PLANNING CONSULTATION RESPONSE

Application No	2026/0726
Proposal	Erection of single storey detached outbuilding to rear of dwelling.
Address	Redminster House, Towngate, Thurlstone, Sheffield, S36 9RH.
Date of Consultation Reply	23/10/2026
Consultee	Edward Jowett (Tree Officer)

Title	Drawn	Checked	Date
Outbuilding - Plans and Elevations	HH	DB	17-07-2026

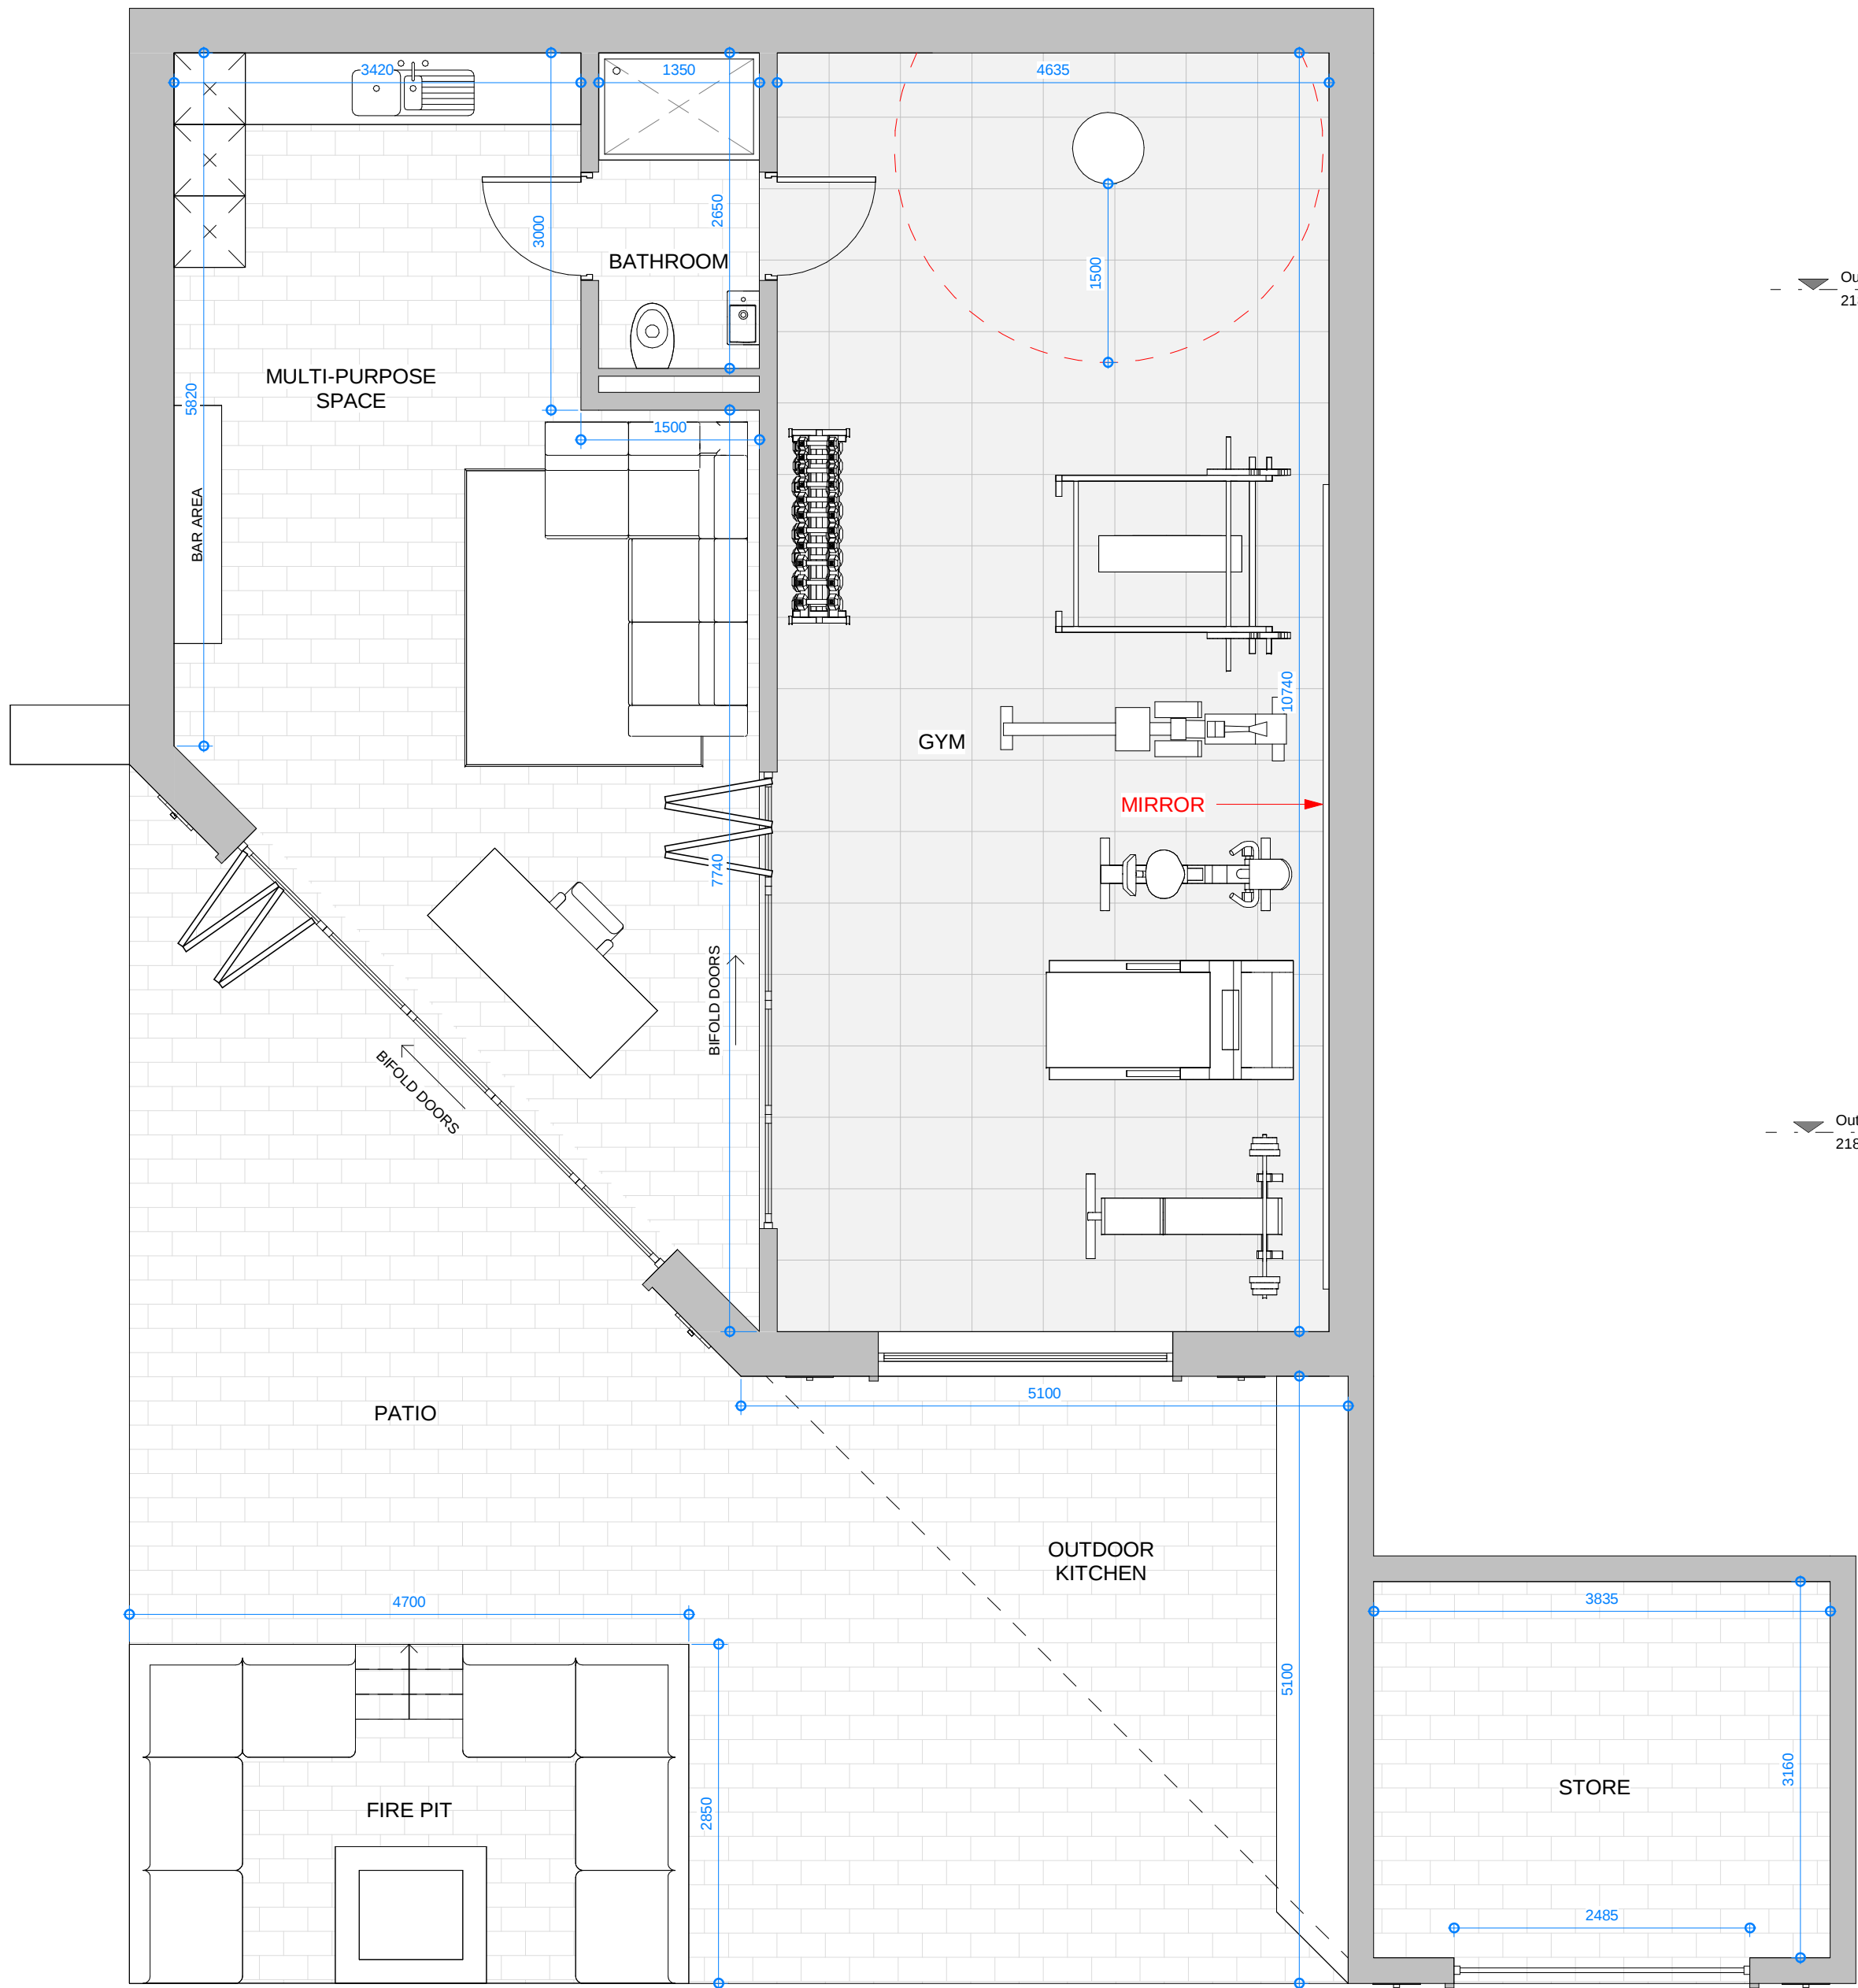
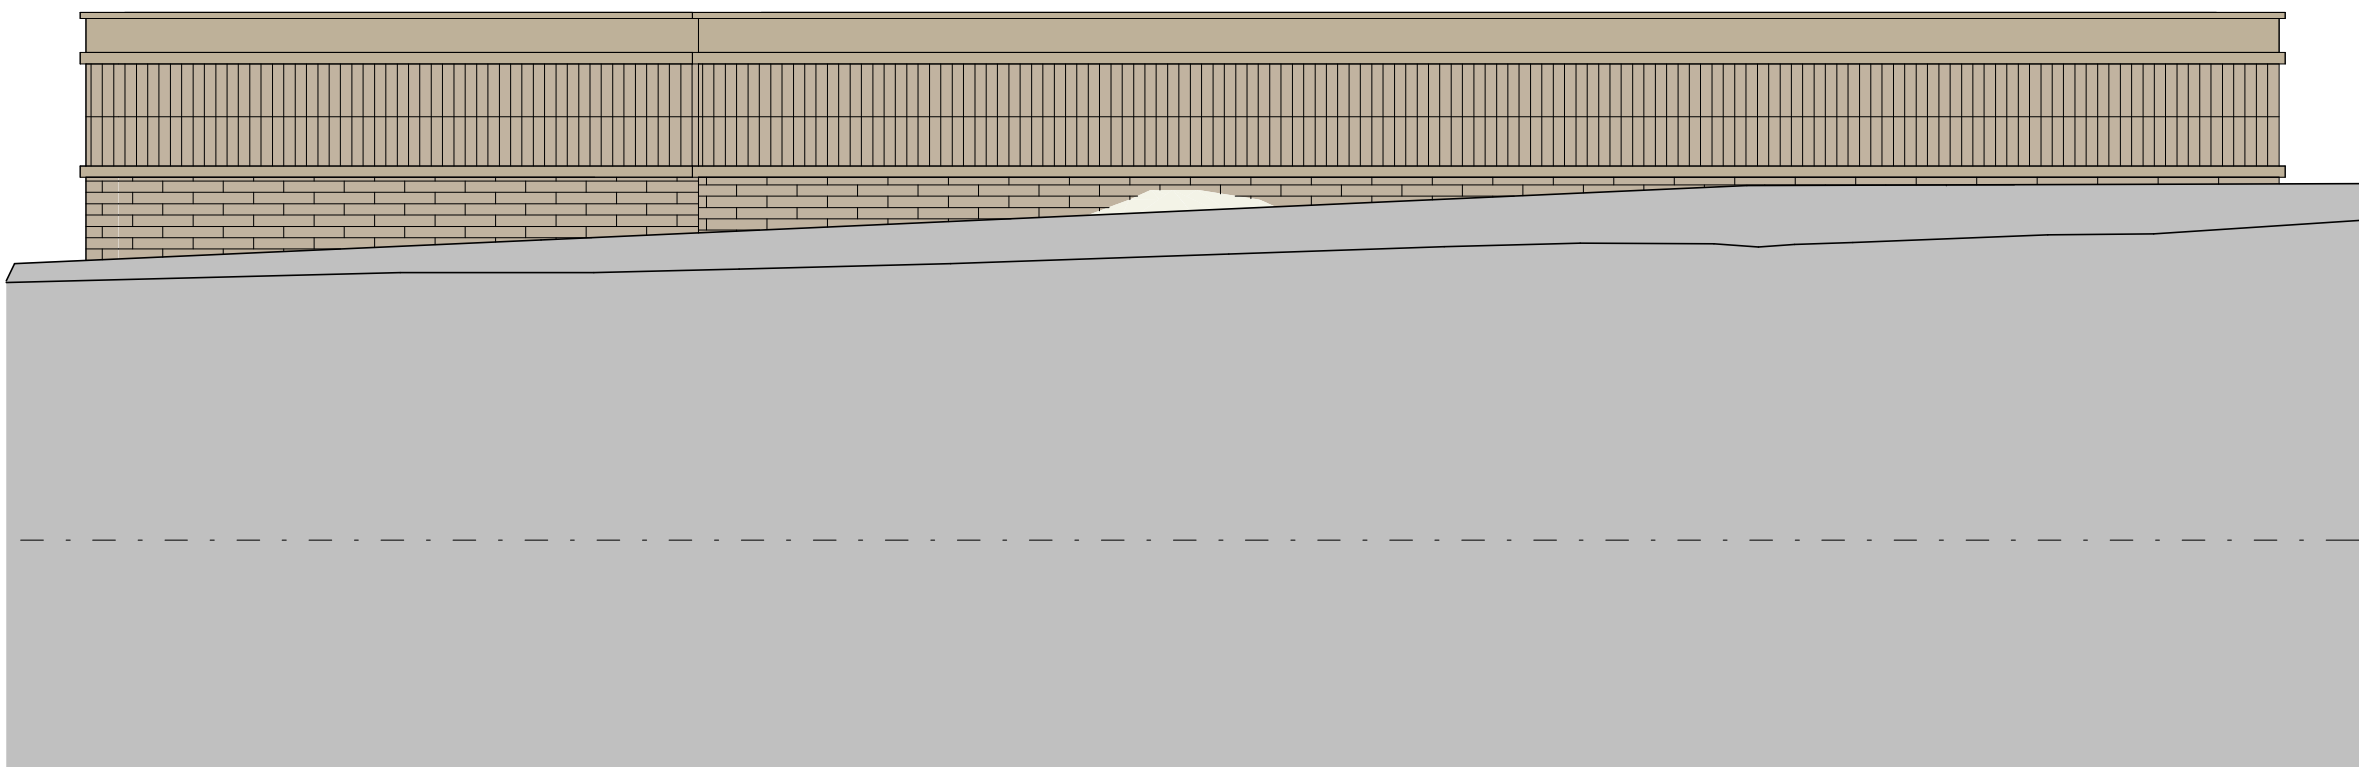
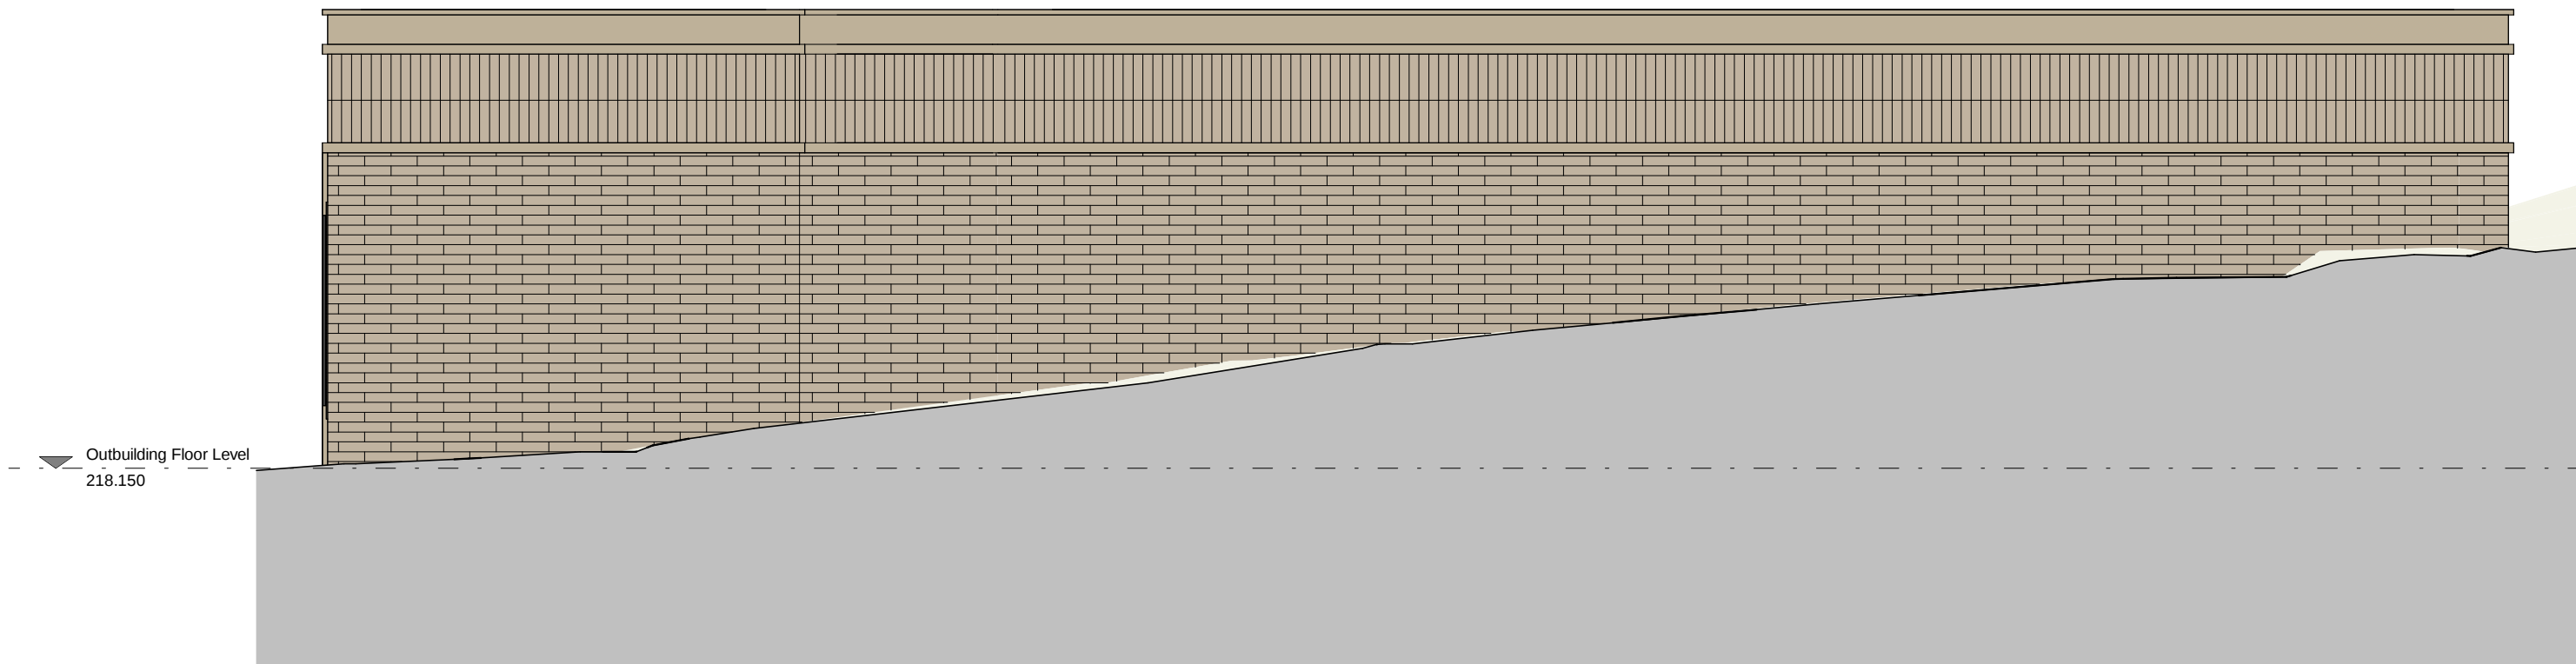
I have significant reservations about the proposed new outbuilding in arboricultural terms. The works proposed will require some significant excavations in the rooting areas of off-site trees T7 and T9. Likewise some trees will require significant reductions back away from the proposed building in order to facilitate the proposal, including some protected by virtue of being located in the Conservation Area. Given that significant works are required to facilitate the scheme I would also have concerns about proximity issues and future pressures on the trees as well as any repeated works becoming disfiguring given trees like T4 still have a significant amount of growth potential left. I therefore feel that the accumulative impacts of excavations, pruning work and potential future pressures/impacts on the off-site trees is a significant issue to which I feel I must object at this stage.

I would therefore ask that the scheme be looked at again and potentially be reduced in scale to minimise the impacts on the rooting areas and canopies of the trees as well as reduce potential future pressure on them due to the close proximity.
